Rezoning Transportation Analysis
Petition Number: Insert Zoning Petition #2020-190
General Location Identifier: Tax ID 12522705

Revision Log:	Date	Description
	01-21-21	First Review (WB)
	02-15-21	Second Review (WB)

General Review Information

SHEET NUMBER
RZ-1

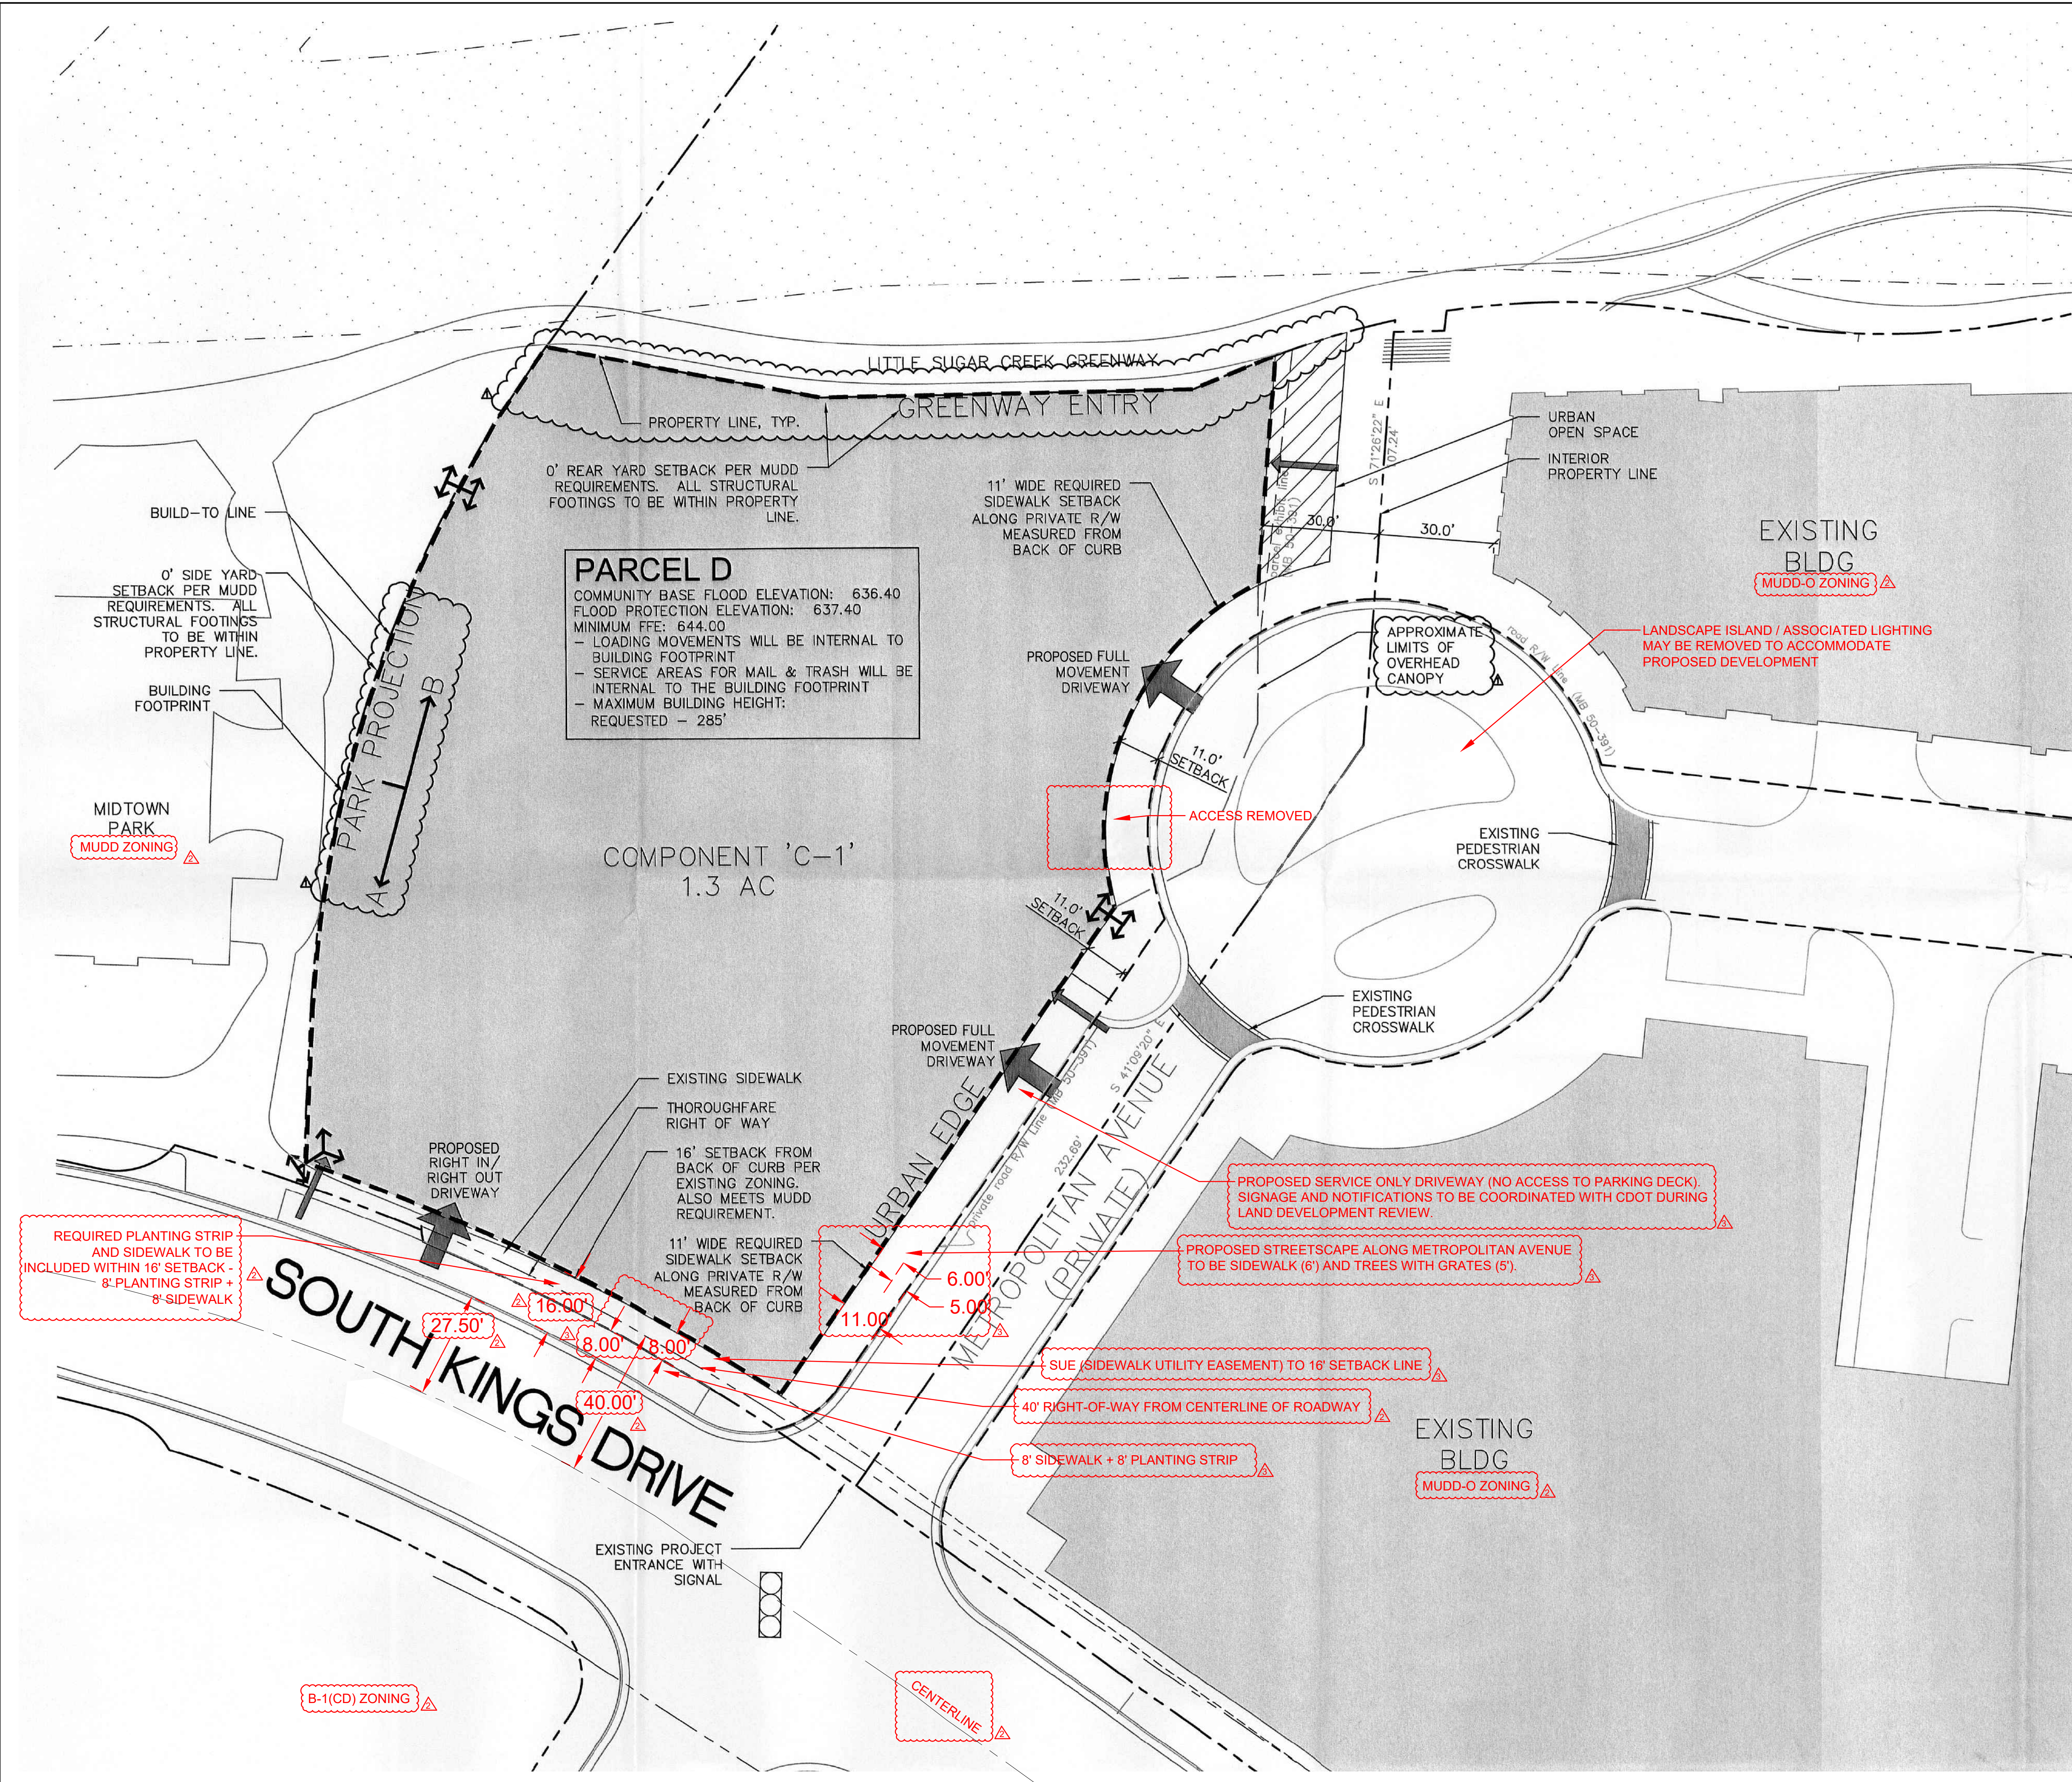
Label and dimension the curb and gutter from the centerline for each road on the site plan.
2. **Traffic Study: (Choose One)**
A Traffic Impact Study (TIS) is not necessary for the complete review of this petition due to the site generating less than 2,500 daily trips. If during the permitting process the site generates more than 2,500 daily trips, then a traffic study will be required.
3. ~~Revise site plan and conditional note(s) to commit to dedicate 40' right-of-way from the South Kings Drive centerline. The site plan shall label and dimension the right-of-way from the road centerline.~~
4. Revise site plan to remove proposed driveways shown within the 200' minimum required offset from a signalized intersection in accordance with the City of Charlotte Driveway Regulations (Chapter 4, page 19).

SHEET NUMBER: **RZ-1**

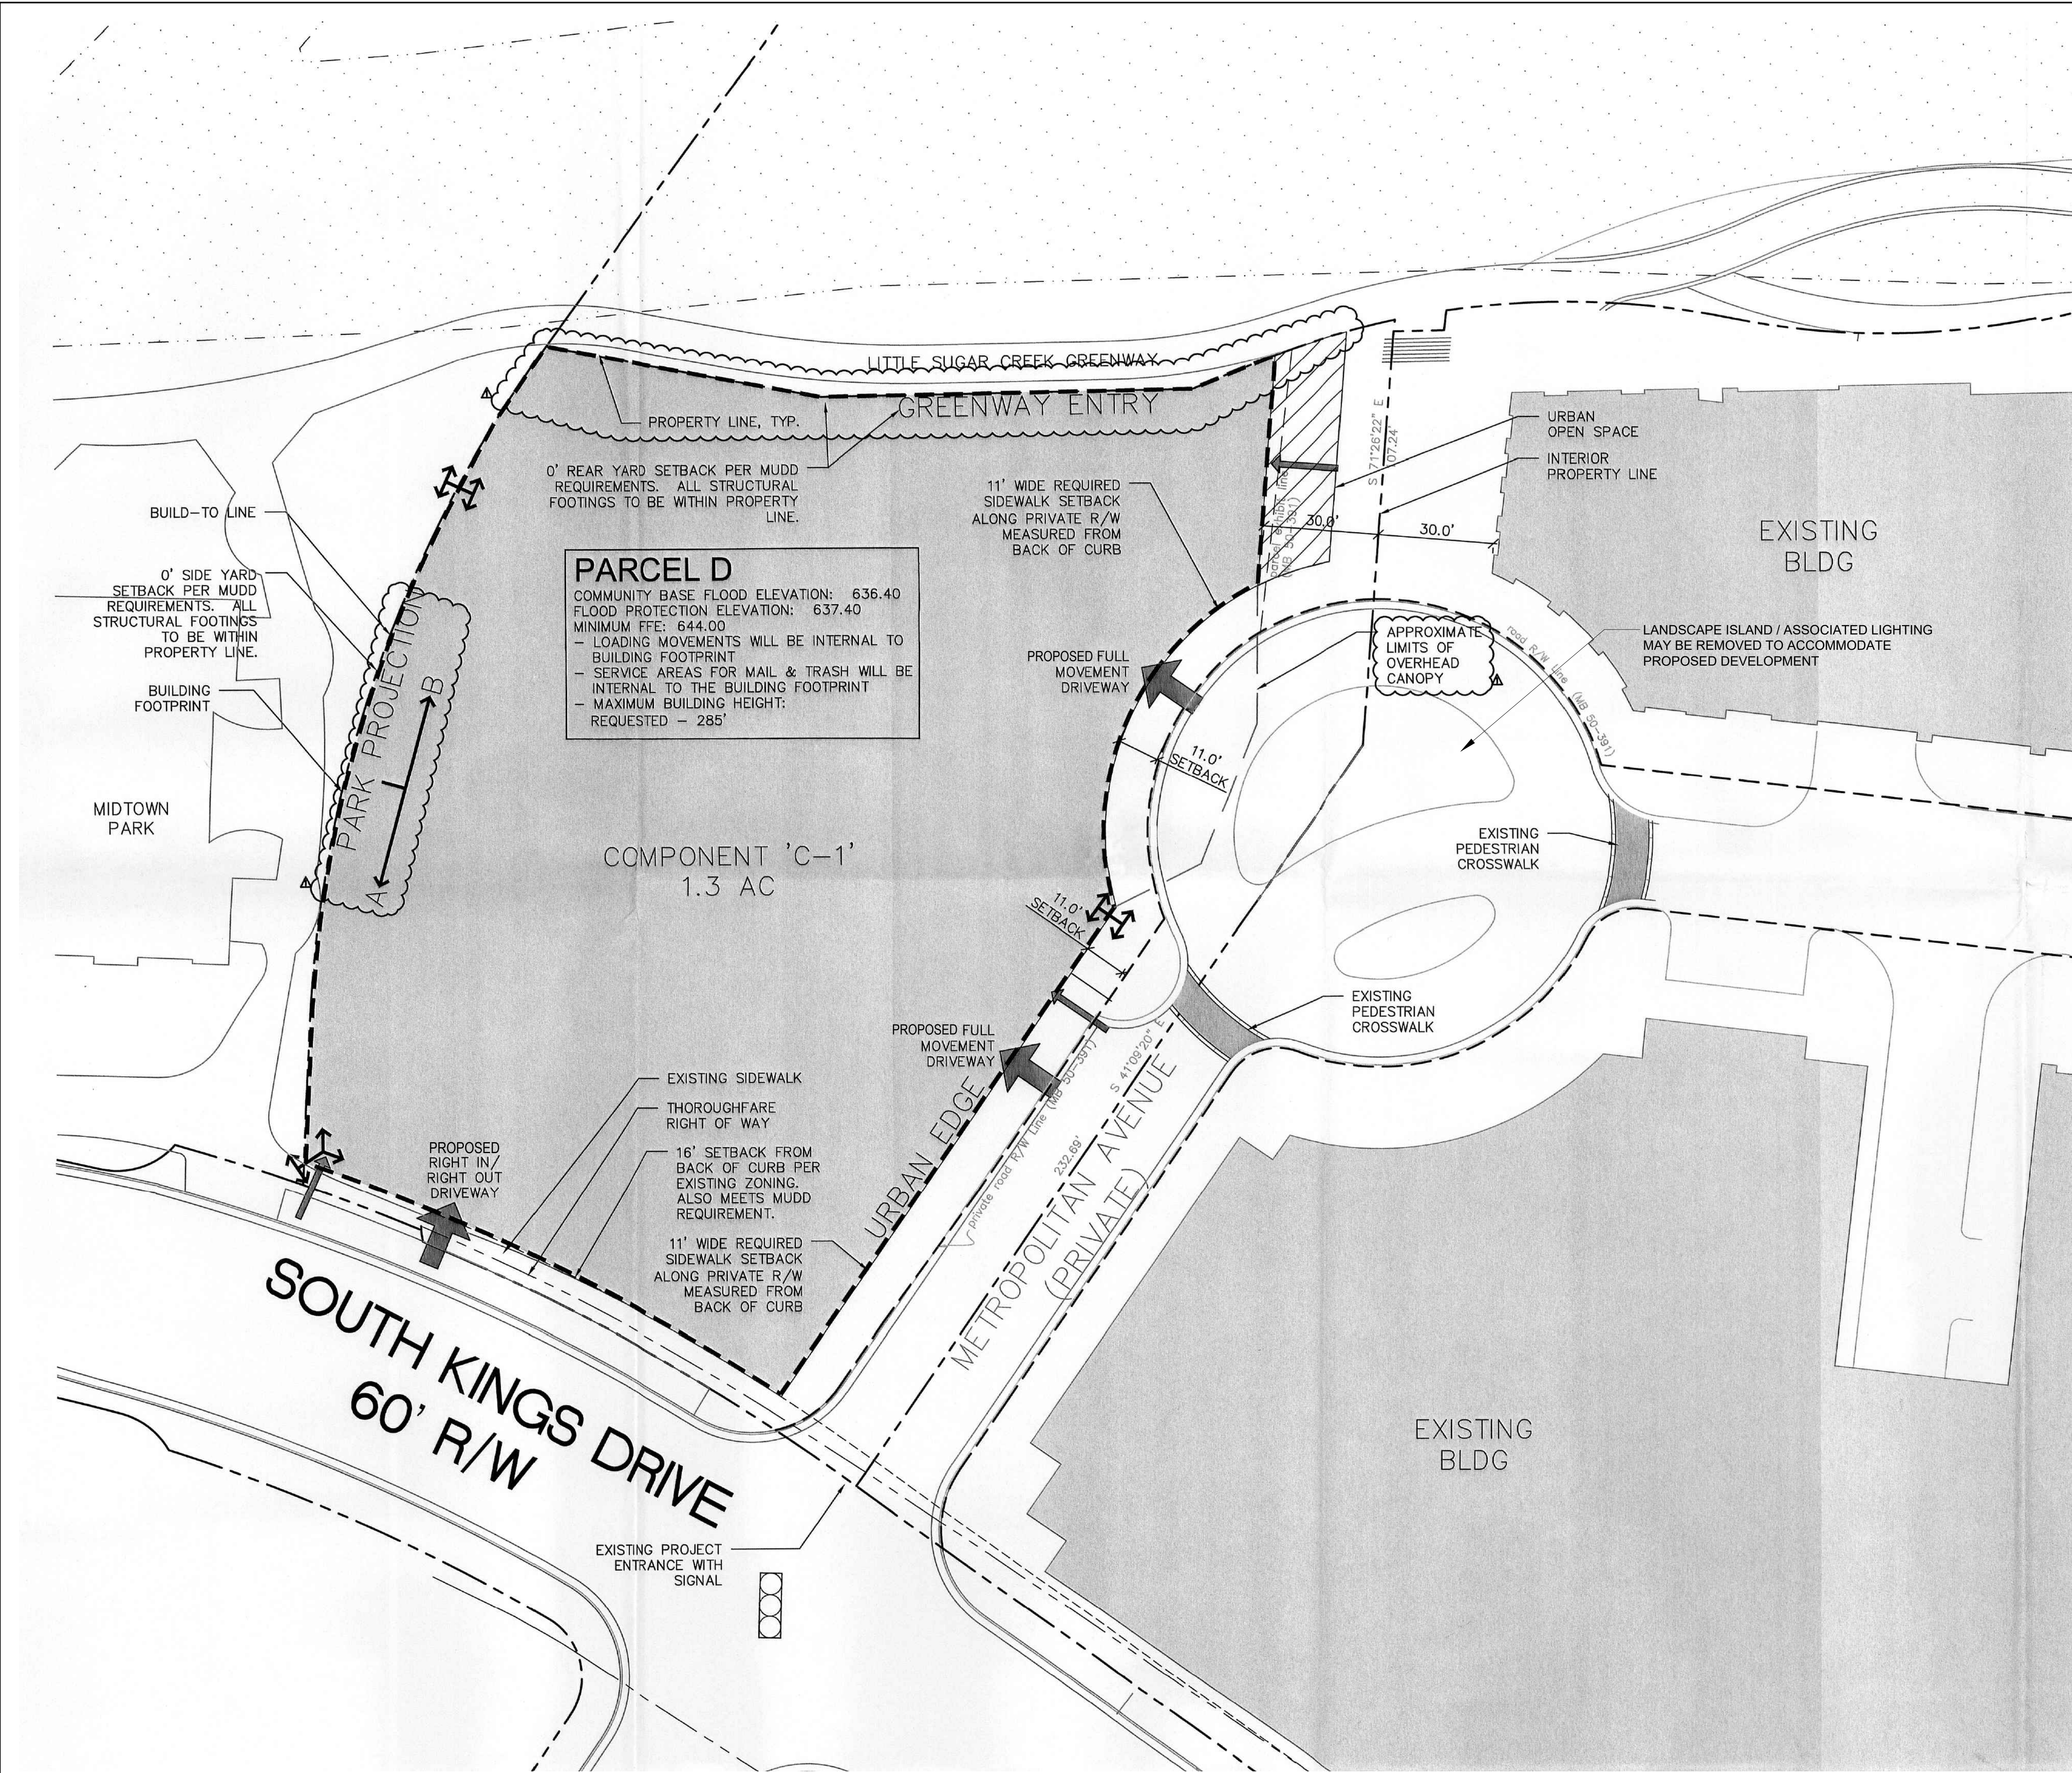
The site is located on a City-maintained, major thoroughfare (South Kings Drive) and a private local road (Metropolitan Avenue). Site plan revisions are needed to meet ordinance requirements and the outstanding items including, but not limited to, dedicating 40' Right-of-way from the South Kings Drive centerline and removing proposed driveways shown within the 200' minimum required offset from a signalized intersection in accordance with the City of Charlotte Driveway Regulations. Further details are listed below.

1. ~~**Curblin**~~: The proposed zoning district has a setback measured from back of the existing or proposed future curblin.
 - a. ~~**Kings Drive**~~: The future location of curb and gutter is in its existing location.

5. A site plan note(s) specifying dedication and fee simple conveyance of all rights-of-way to the City before the site's first building certificate of occupancy is issued is needed. CDOT requests rights-of-way set at 2' behind back of sidewalk where feasible.
6. A site plan note specifying that all transportation improvements will be approved and constructed before the site's first building certificate of occupancy is issued is needed. The petitioner may phase transportation improvements if said improvements and phasing are explicitly described in site plan notes.
